Appeal Decision

Appeal Ref: APP/C3810/D/12/2187319

Sandgate House, South Strand, East Preston, Littlehampton, West Sussex, BN16 1PN

1207 SK23
Sandgate House, East Preston
First Floor As Proposed
June 2012
scale: 1:100

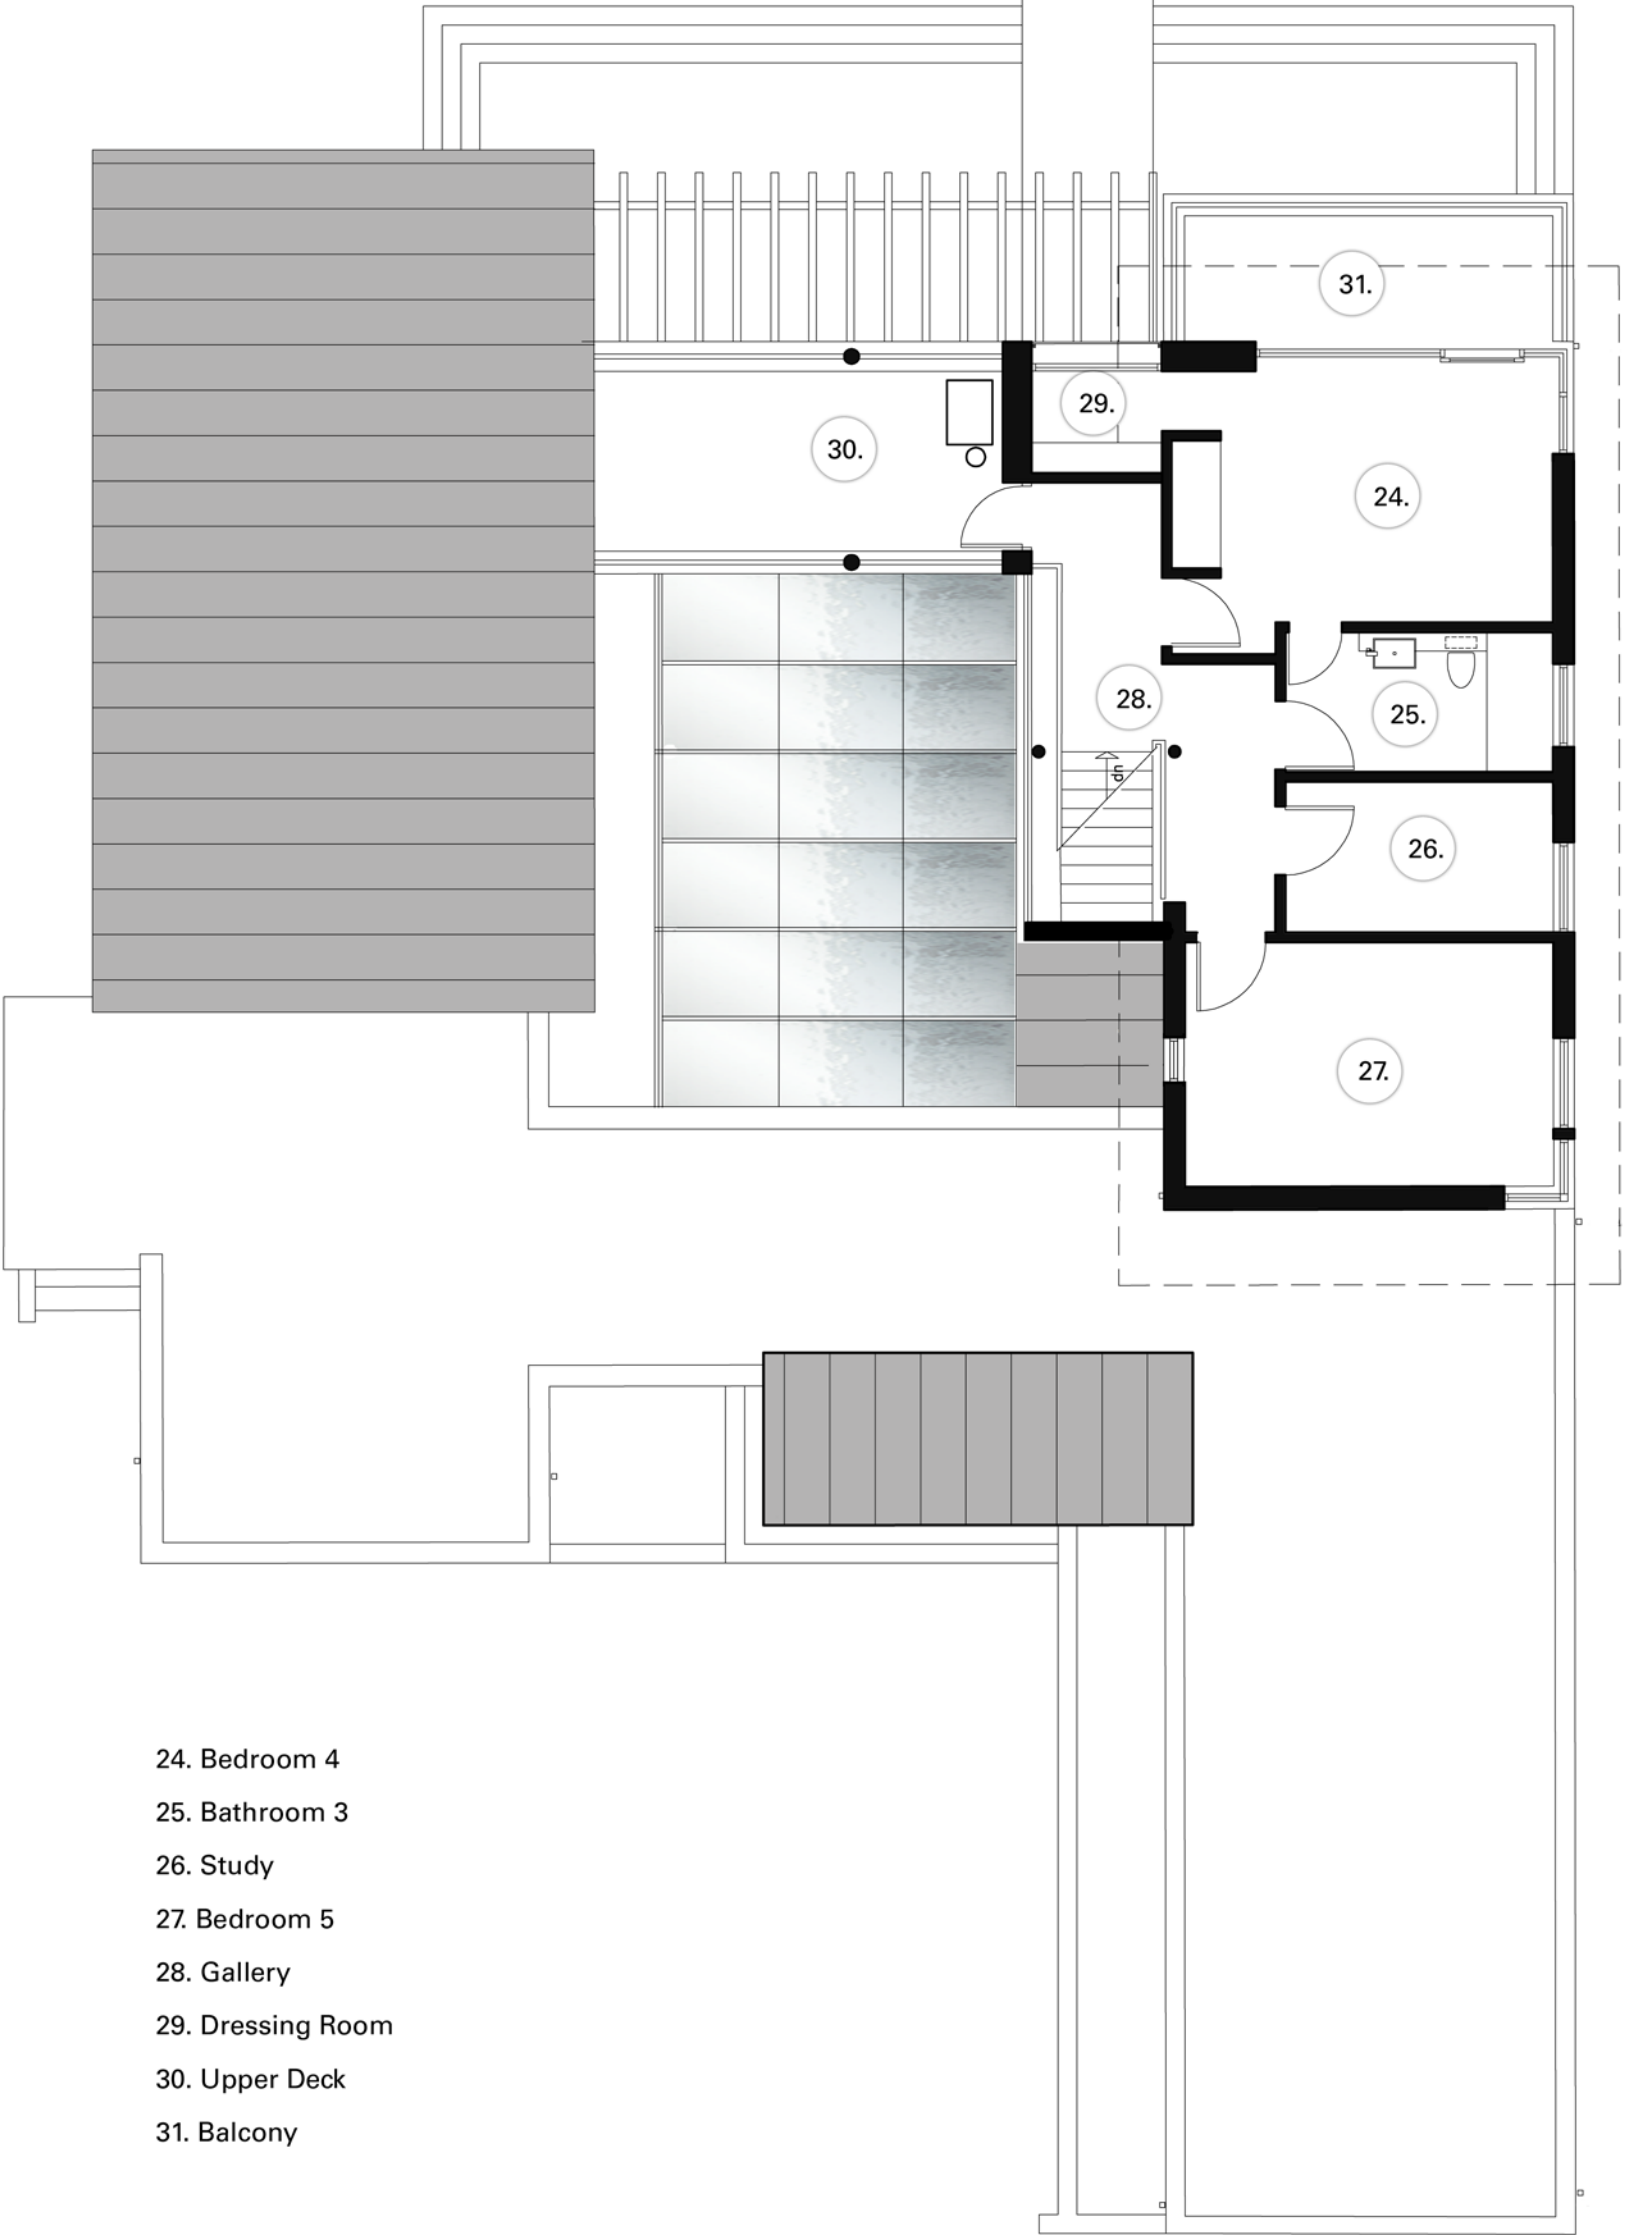
4. The proposal would replace the pitched roof with a monopitch roof and provide first floor accommodation over part of the south west corner of the property. The overall design would accurately be described as contemporary and there is no objection in principle to this approach. Indeed the National Planning Policy Framework confirms that architectural styles or particular tastes should not be imposed and innovation should not be stifled. However, it is also important that new development is of a high standard of design which adds to the overall

6. There is some planting around the appeal site but the first floor element of the proposed development would nevertheless be visually prominent, both from the beach and from the main garden areas of Lar-Chess and Spindrifft. Although in other circumstances the use of timber cladding, the appearance of the fenestration and the form of the roof (including the large overhangs) may be appropriate, in this setting they would combine to present a dwelling that would appear incongruous and overly dominant.

1207 SK25 A
Sandgate House, East Preston
Elevations As Proposed - sheet 1
June 2012
scale: 1:100

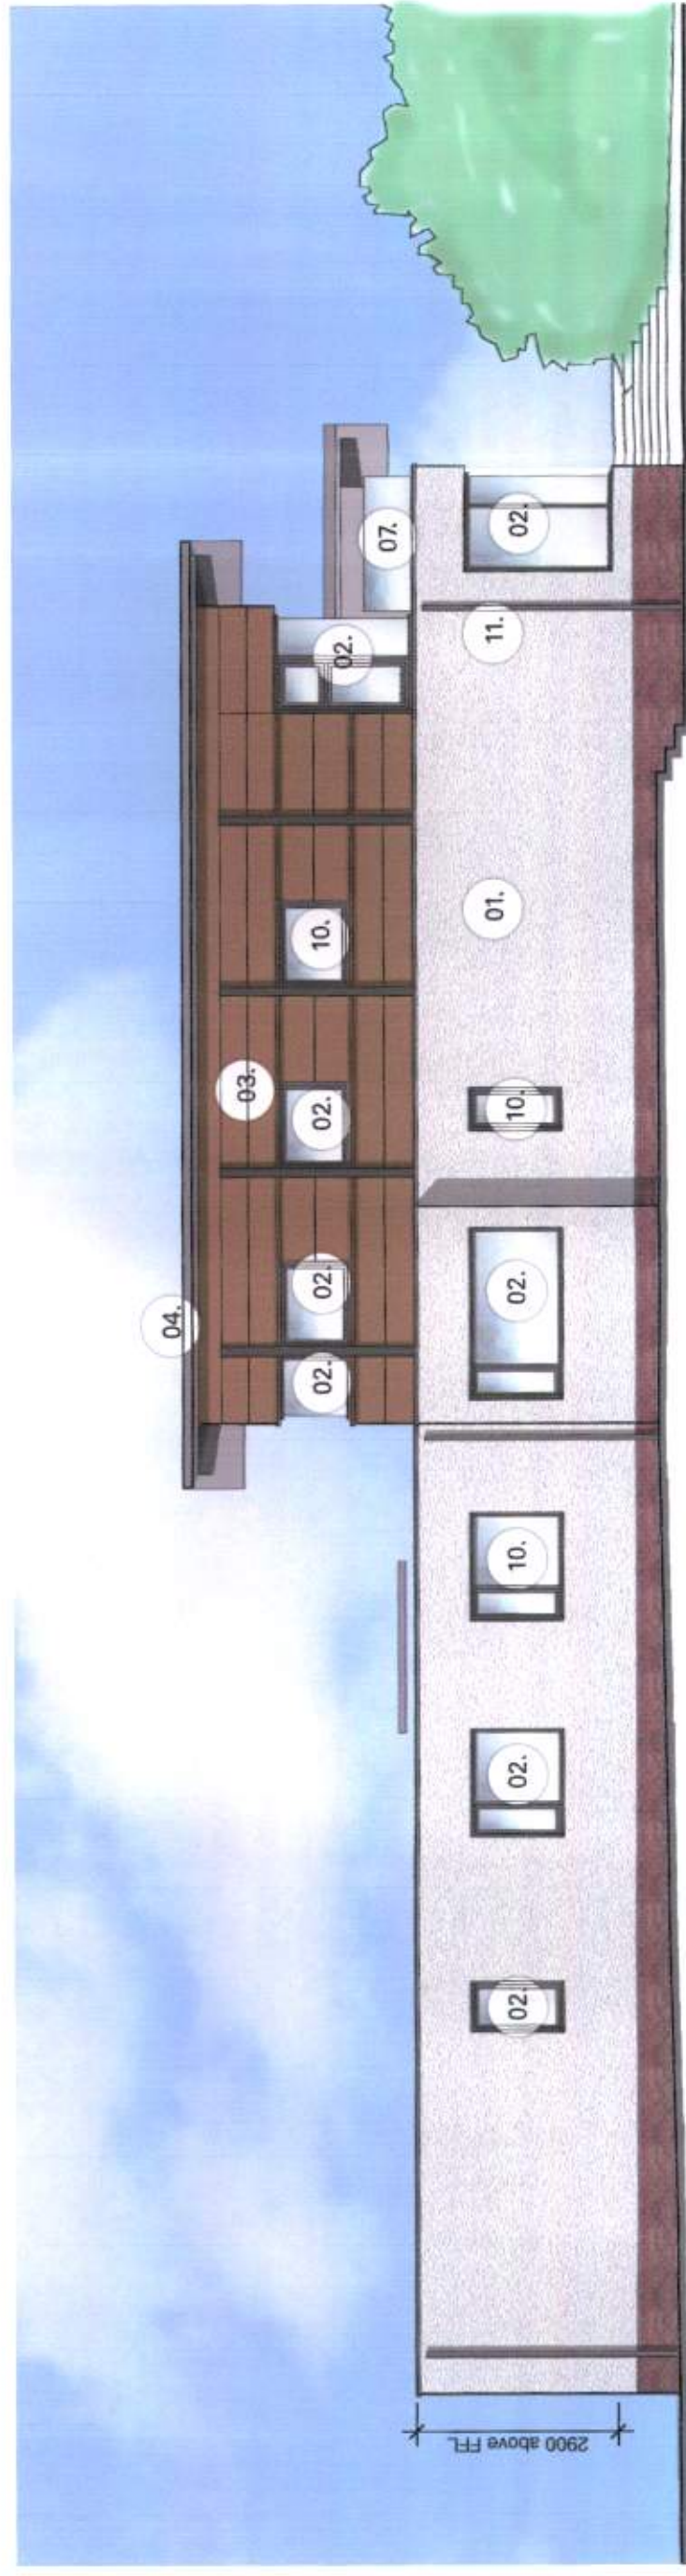
8. The Design and Access Statement refers to the provision of obscure glazing in the western elevation and I note that one of the Council's suggested conditions would require obscured glass to be used at first floor level in that elevation. This would result in obscure glass being used in the window to the proposed study and in most of the main window to bedroom 5, which I consider would be to the detriment of the living conditions of the occupiers. Although this is not a matter on which my decision turns it adds weight to my overall conclusion. Reference is also made by the appellant to two other schemes that have been granted planning approval but I have been given no details of those proposals and can therefore give them little weight.

1207 SK26A
Sandgate House, East Preston
Elevations As Proposed - sheet 2

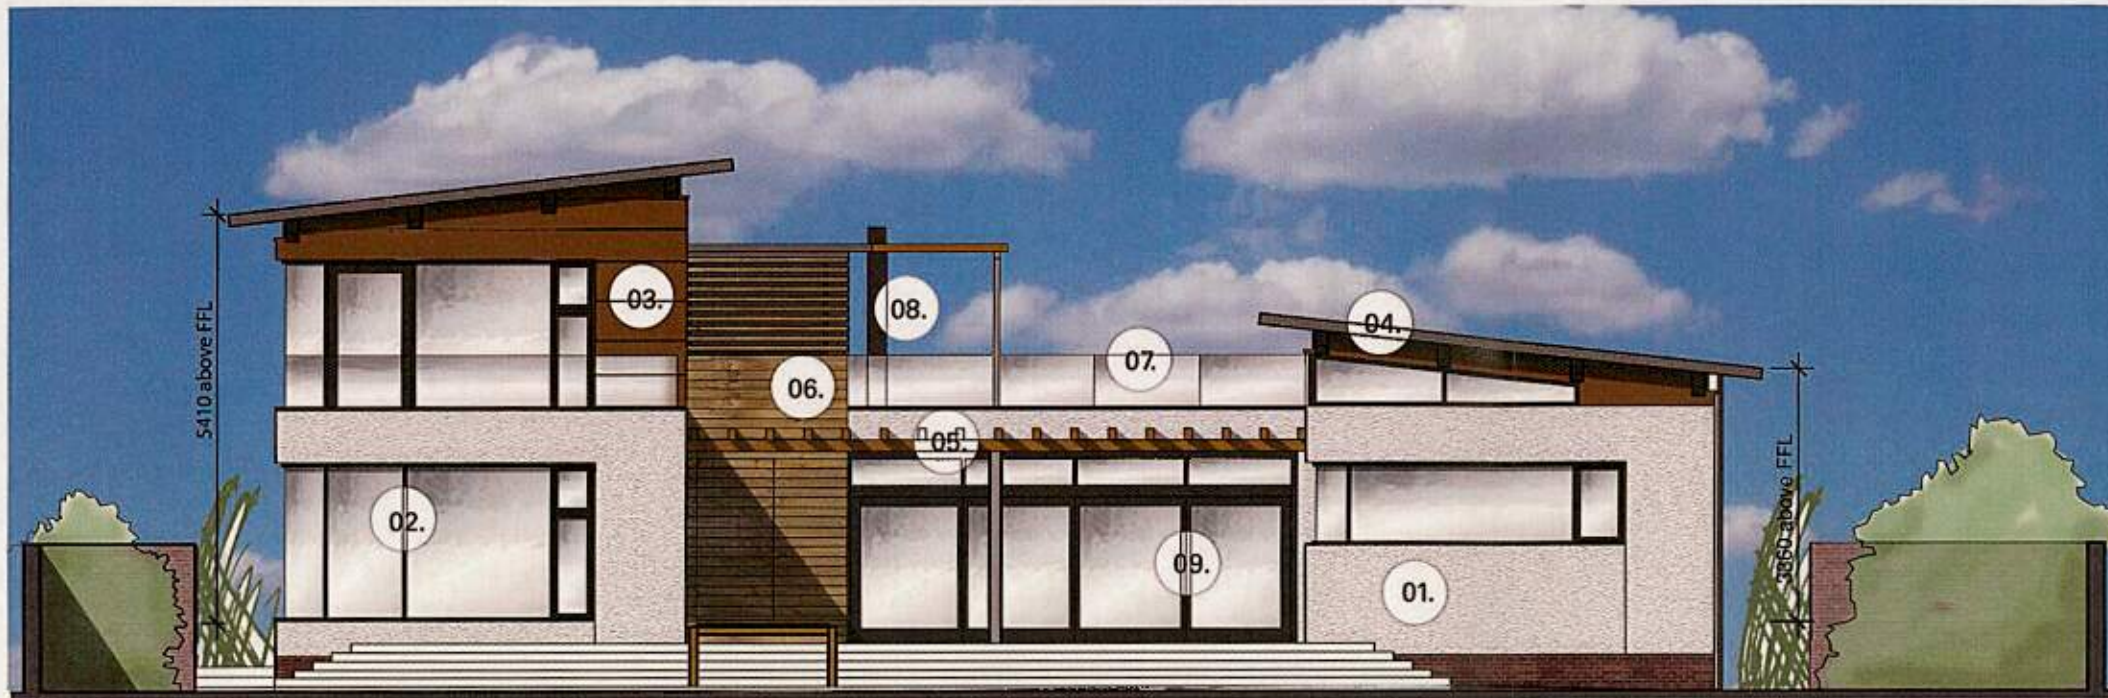
7. The appellant suggests that despite the provision of a new first floor, the removal of the existing pitched roof would reduce the bulk of the building. However, within the context that it sits I do not consider the appearance of the existing bungalow to be unduly bulky or out-of-place and the increase in height of the property to two storeys, albeit only on the western side, would introduce a 'new' element of built form that because of its design would add to the bulk of the property.
